memorandum

date December 7, 2016

subject Proposed NFH Single Family Residence (CA016-002) – Environmental Review

### PROPOSED ECOLOGICAL IMPROVEMENTS

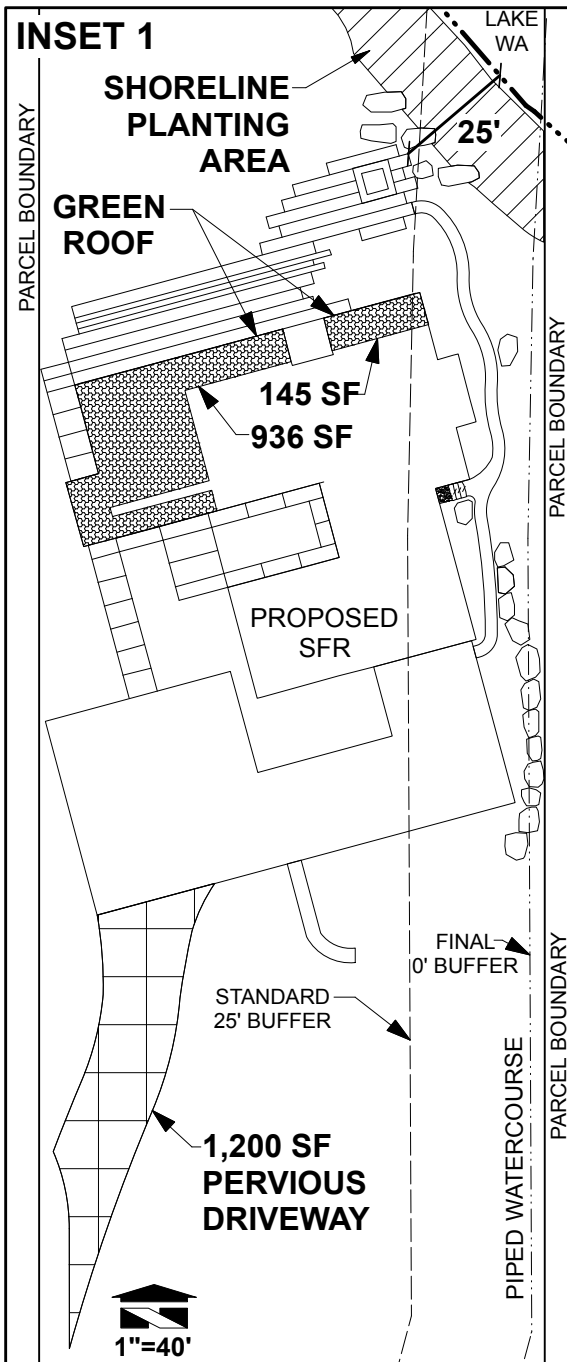
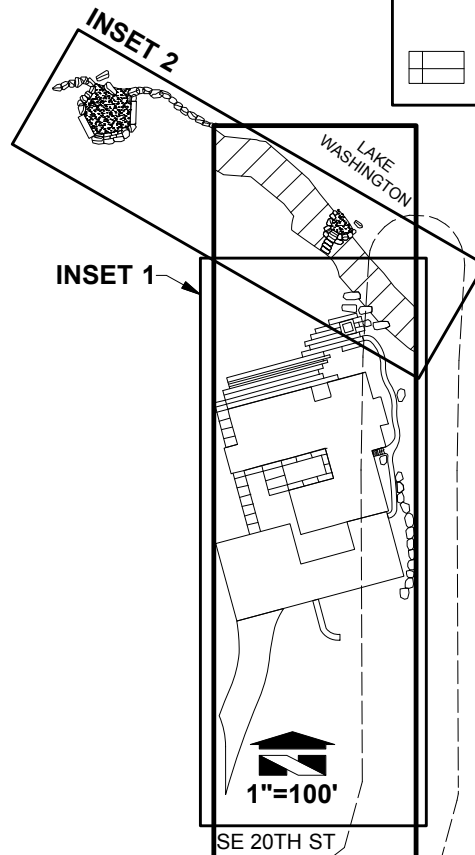
While the proposed pervious driveway and green roof may provide limited water quality benefit to Lake Washington, we do not believe that these proposed actions will improve functions for the piped watercourse itself. Our understanding is that the City’s critical areas requirements provide a buffer around piped watercourses in order to allow for future restoration of the stream channel and removal of the piped condition (daylighting). Consistent with this intent, it is our interpretation that reduction in the standard 25-foot buffer for piped watercourses may only be allowed where the mitigation provided enhances the piped watercourse (or potentially, other off-site watercourses within the City), such as potential upstream restoration or actual daylighting, consistent with options provided by MICC 19.070.070.B.2.b.viii and x:

ESA does not believe that the proposed green roof and pervious pavement would provide adequate mitigation for proposed site development within the standard 25-foot buffer of the piped watercourse, as these features would not specifically enhance the ecological functions of the piped watercourse.

**MITIGATION &
RESTORATION
PLAN**

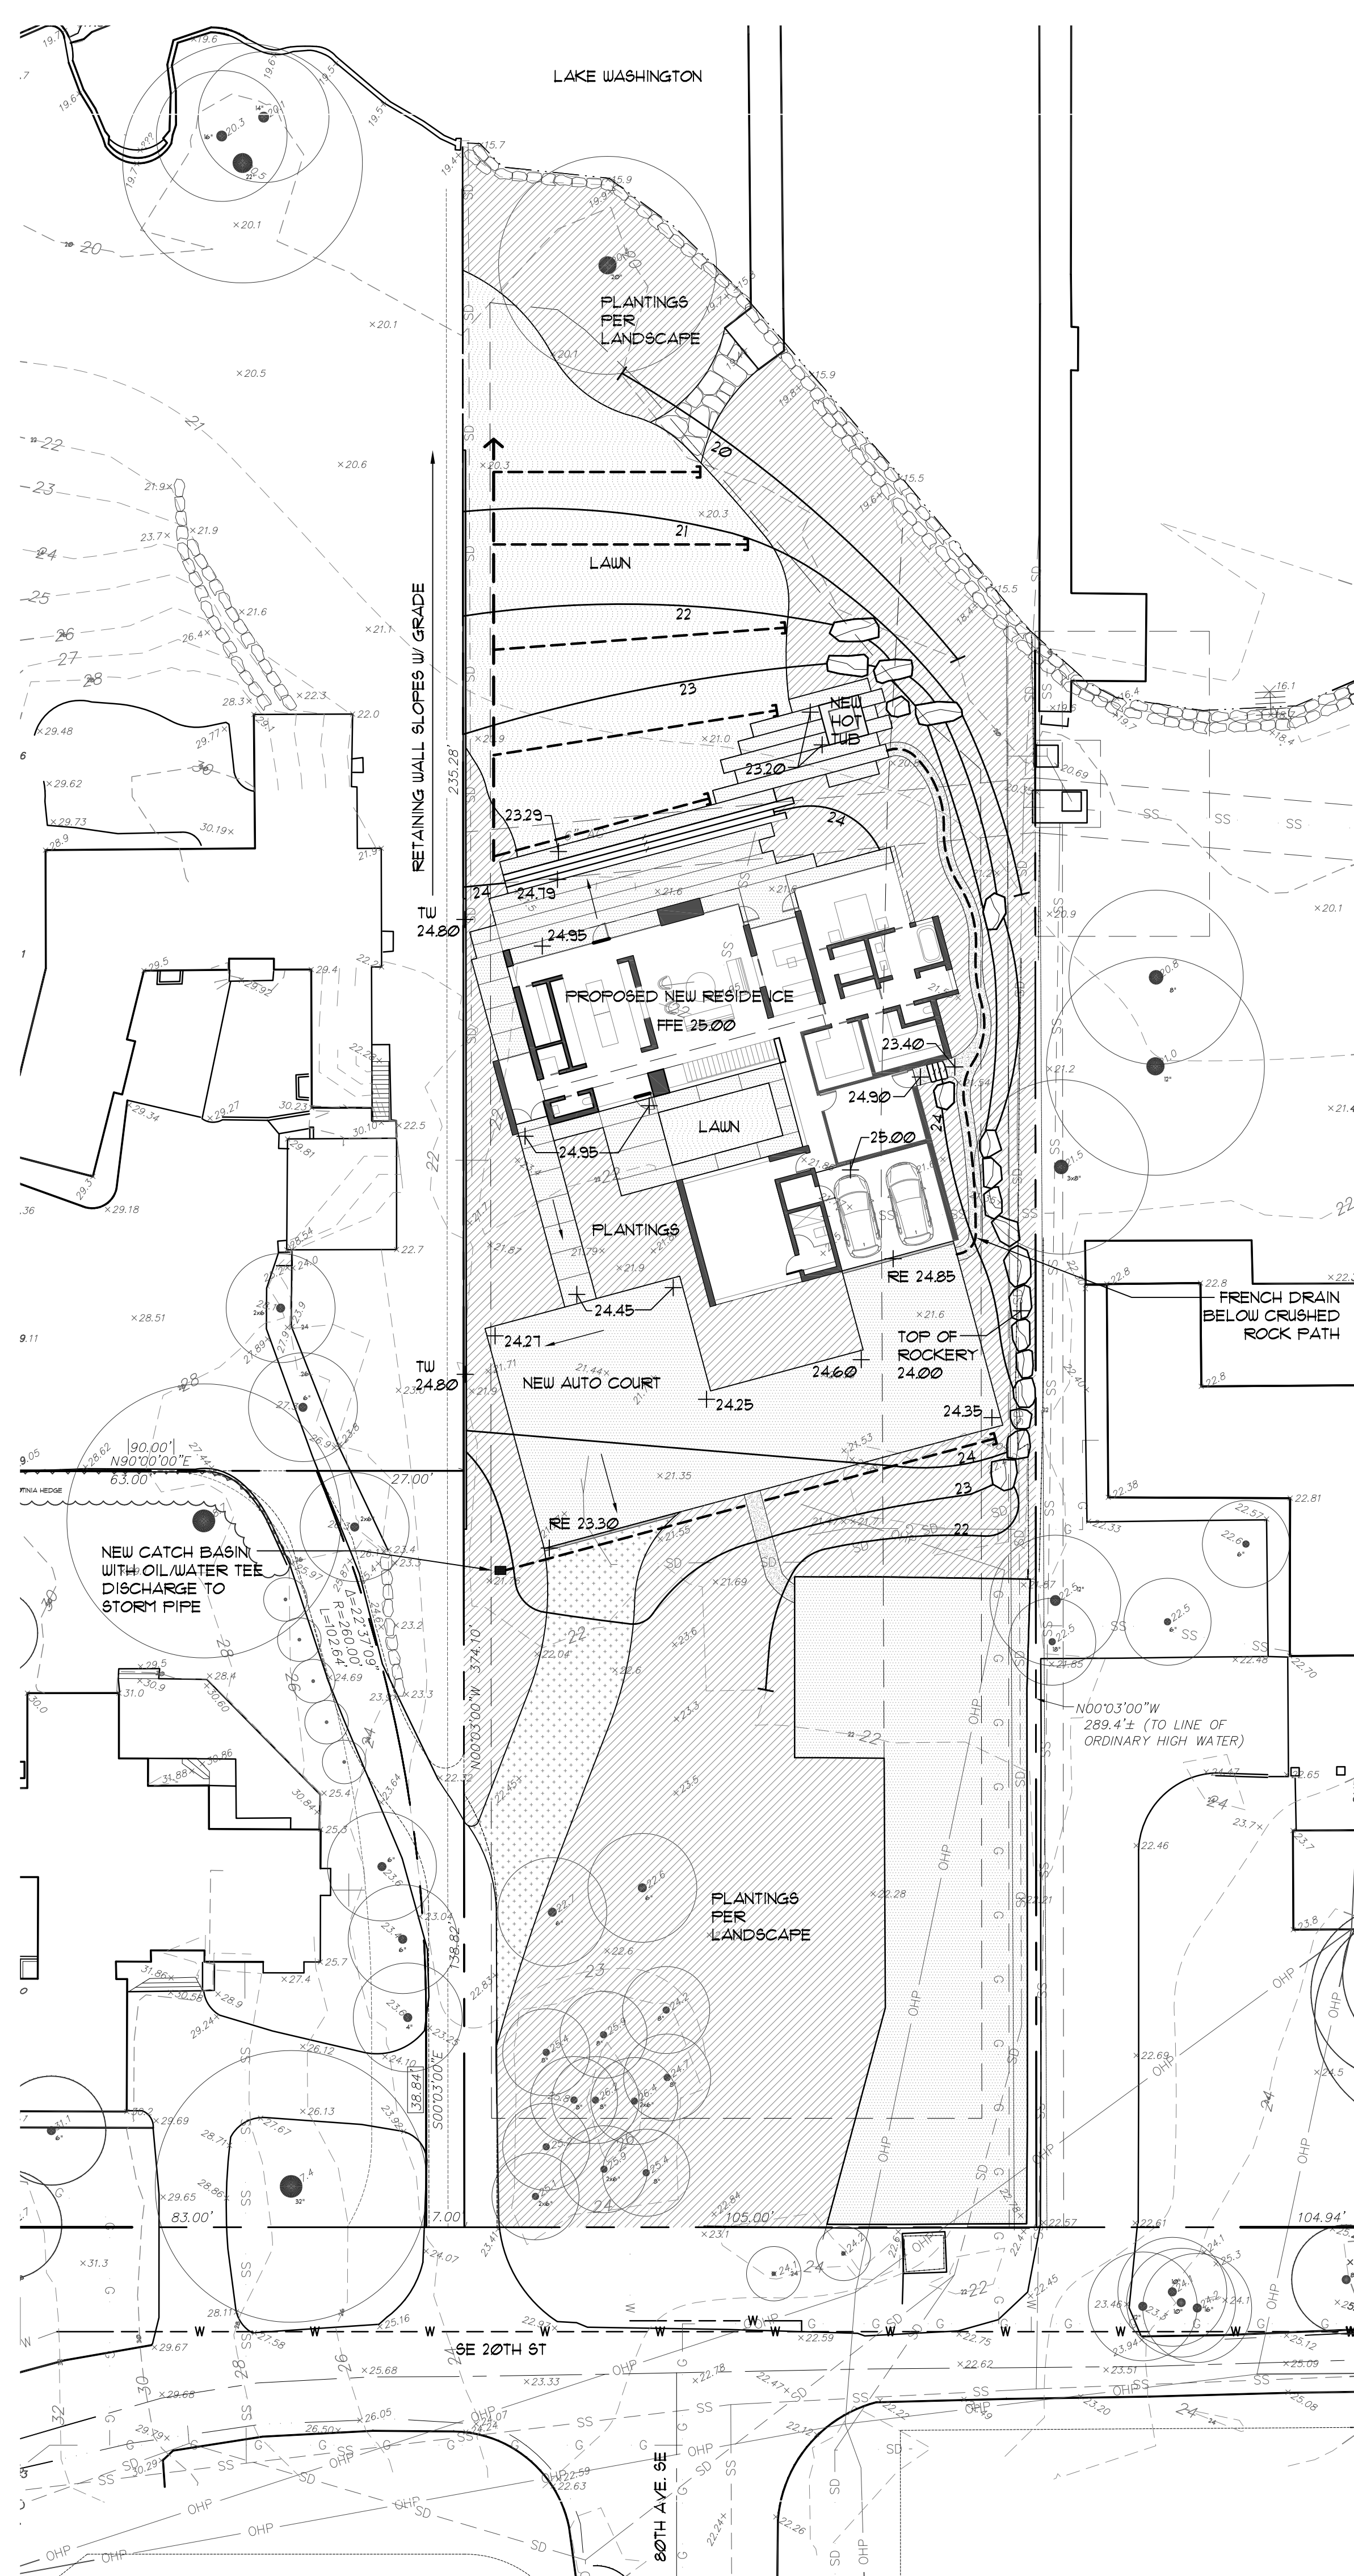
2. Updates to the proposed Project Plans, including the Mitigation & Restoration Plan, to reflect additional site analysis focused on wetlands and potential additional mitigation (if wetlands are identified); and

3. Revision to the proposed mitigation approach to justify piped watercourse buffer reduction. Proposed mitigation should be focused on restoring the specific functions of the piped watercourse, such as considering opportunities for off-site restoration of a watercourse within the City or daylighting a section of the stream channel at and immediately upstream of the Lake Washington convergence. See review discussion and detailed recommendations on page 3 of this memo.
